From: Louise Bearcroft
Sent: 24 March 2026 15:15
To: DC Admin
Subject: FW: Objection Planning Application 2025/92713 Re: TPO Number 05 of 2025

Please can you log this as an objection to 2025/92737 and 2025/92713.

Once again, I have viewed a new plan submitted for this proposed PPJ development. I have done my utmost to protect 8 beautiful, very large wild cherry trees that are in good health, from this development. Once again the developers agent has submitted a new Proposed Site / Block Layout [id 1124987] dated 4th Feb 2026 Planning Application 2025/92713, that shows fully grown and growing trees **that have been miniaturized on this plan and now appear to be some sort of big hedge, in my garden. These very large trees are not a hedge and do have a Tree Protection Order on them.**

Tree Preservation Order No. 05 of 2025

Tree Protection Plan to BS5837:2012 at:
Moor Lane, Gomersal

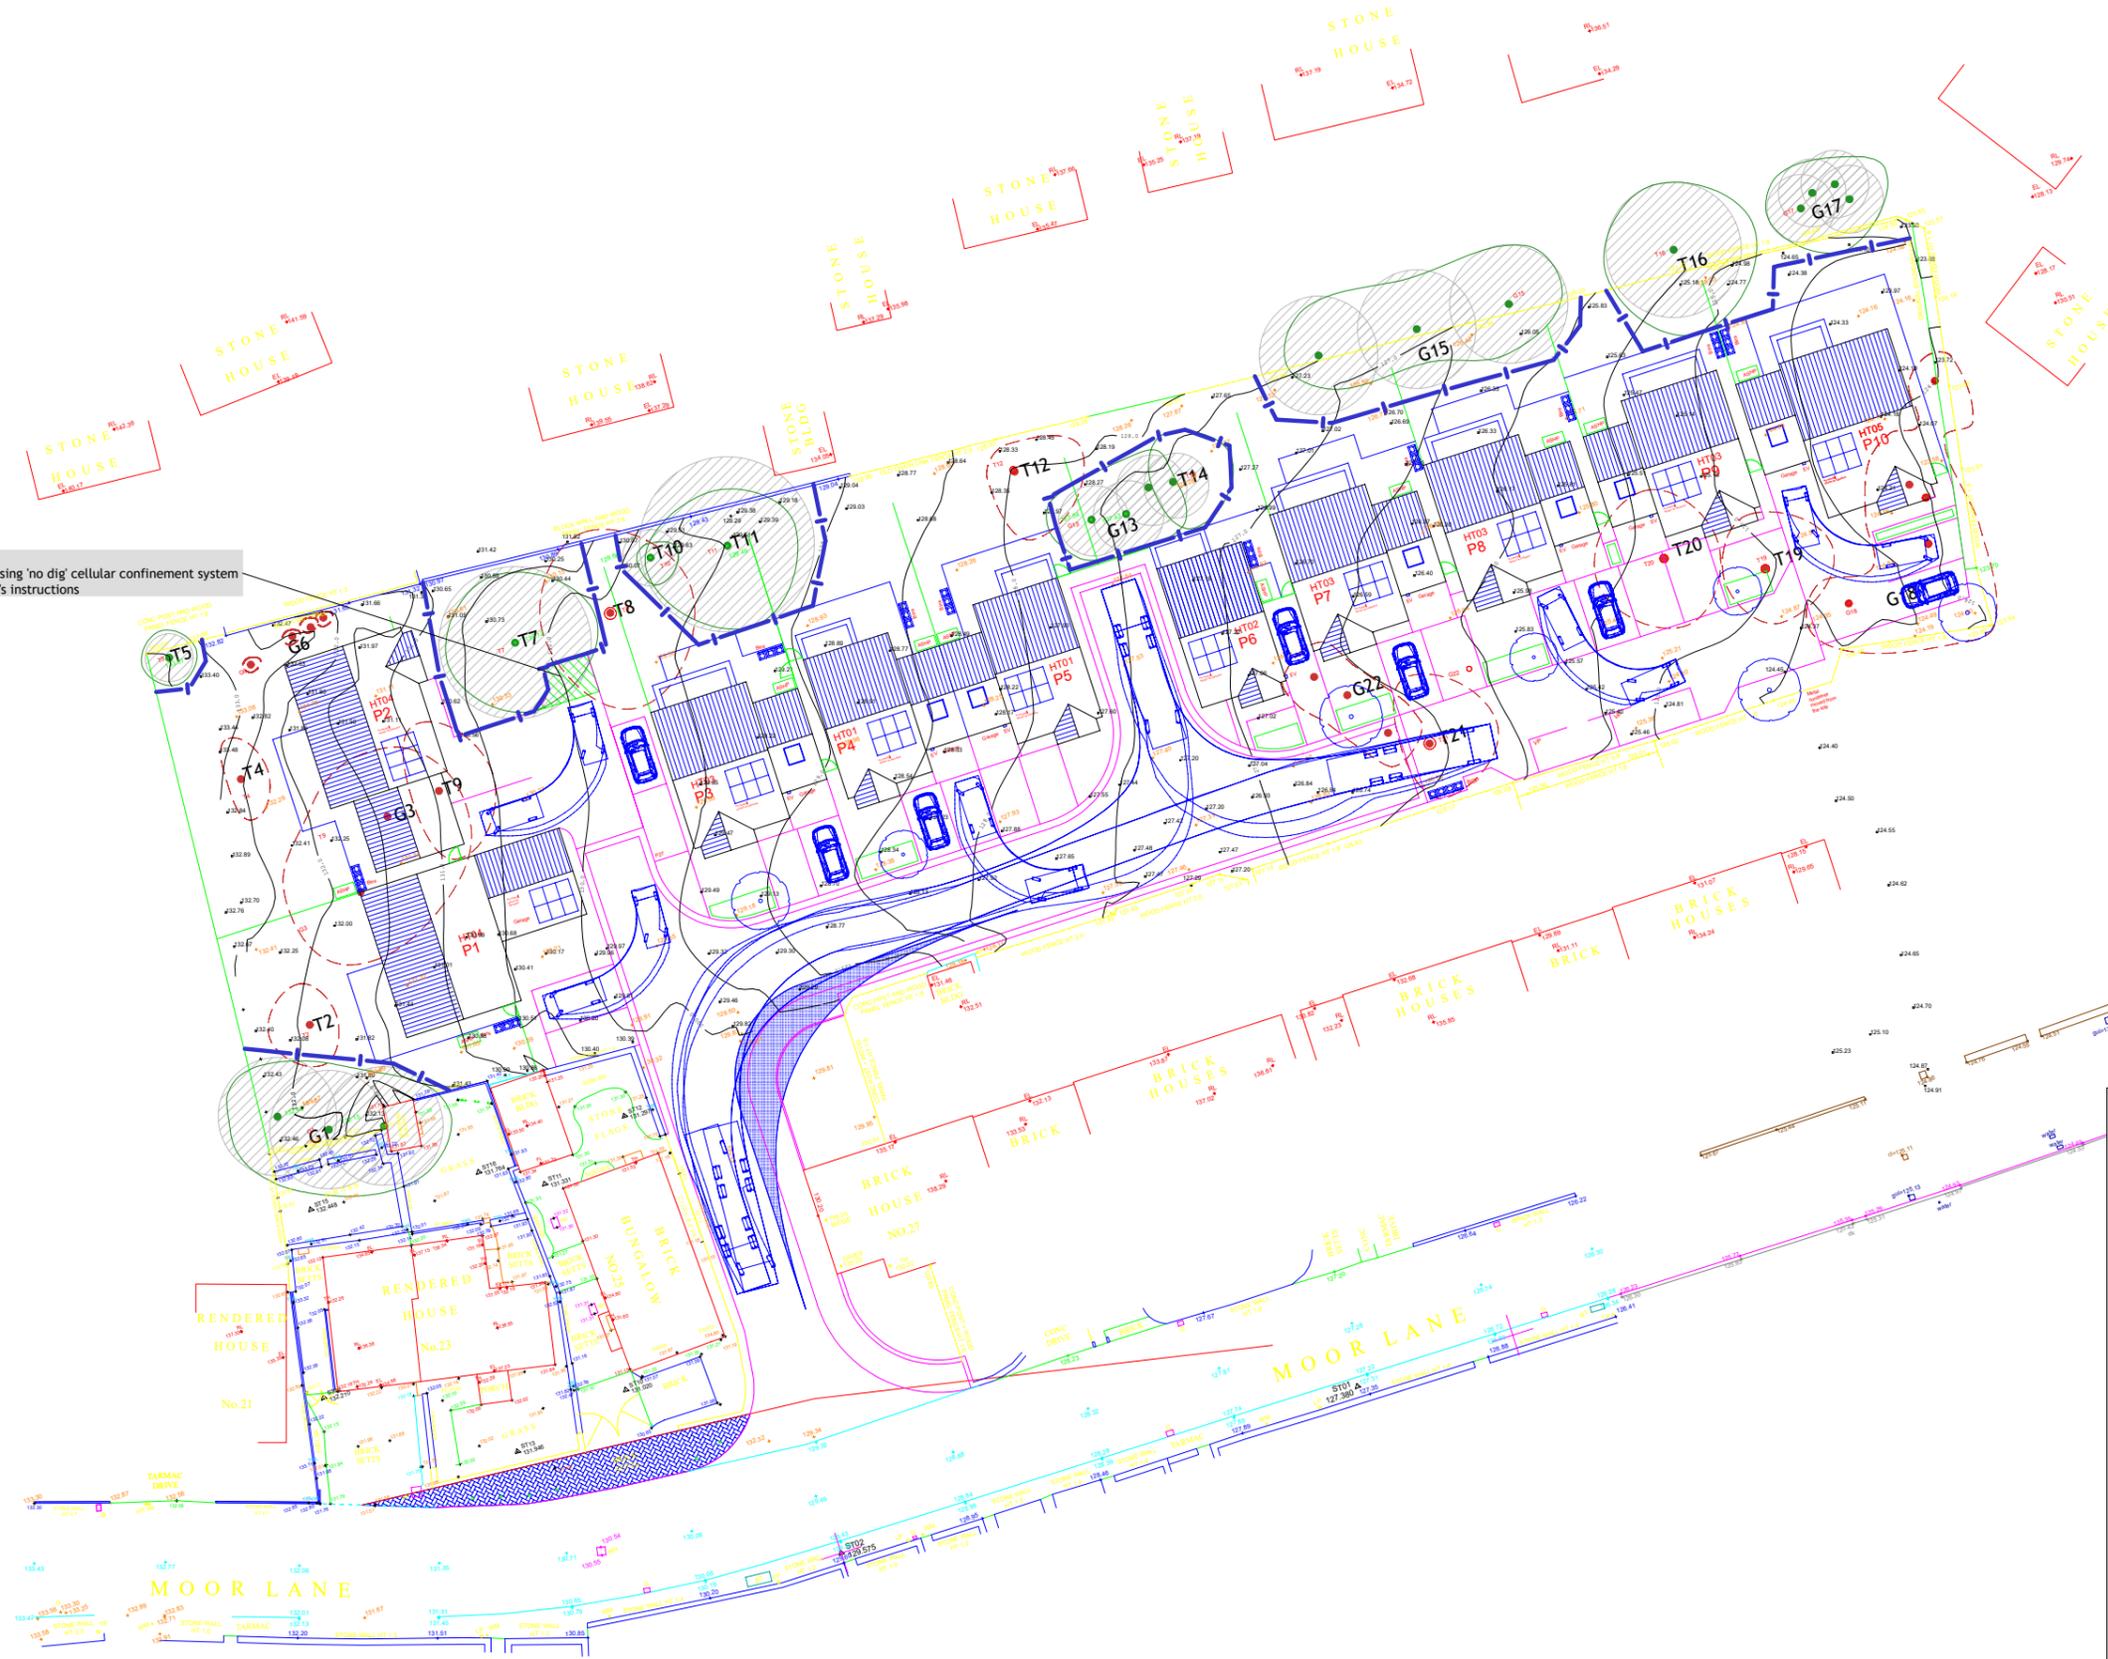
The most recent plan uploaded by Kirklees Planning [id1130493] dated 12.03.2026 is still showing tree T16 as its actual size but showing G17 group of trees, smaller, just marginally larger than the garage shown to the right of them. Therefore the root balls are shown as extending only just over the boundary whereas the branches of these trees extend further over the boundary than T16's do. As stated in my original email some of the branches from these cherry trees extend to approx. 5 metres over this proposed development site.

This TPO does not seem to have been acknowledged because the true **status, size and quantity** of our cherry trees have not been updated on these amended plans. This means the size of the trees and the root balls are being shown to be considerably smaller than the tree growing to the left, (**West**) on the plan labelled Proposed Site / Bock Layout [id 1124987 **T16 (Protected TPO Tree)**]. Some of our mature cherry trees are as big as T16. Therefore the trees in my garden have been given far too little root protection area that should have been allocated, to protect these beautiful trees, from this developer.

- 4) Please can the developer and his agent be advised to show the tree canopies on his plans that are the correct size, proportion and diameter as TPO Tree T16, as people may be **mislead** into thinking that these trees are smaller than they really are.
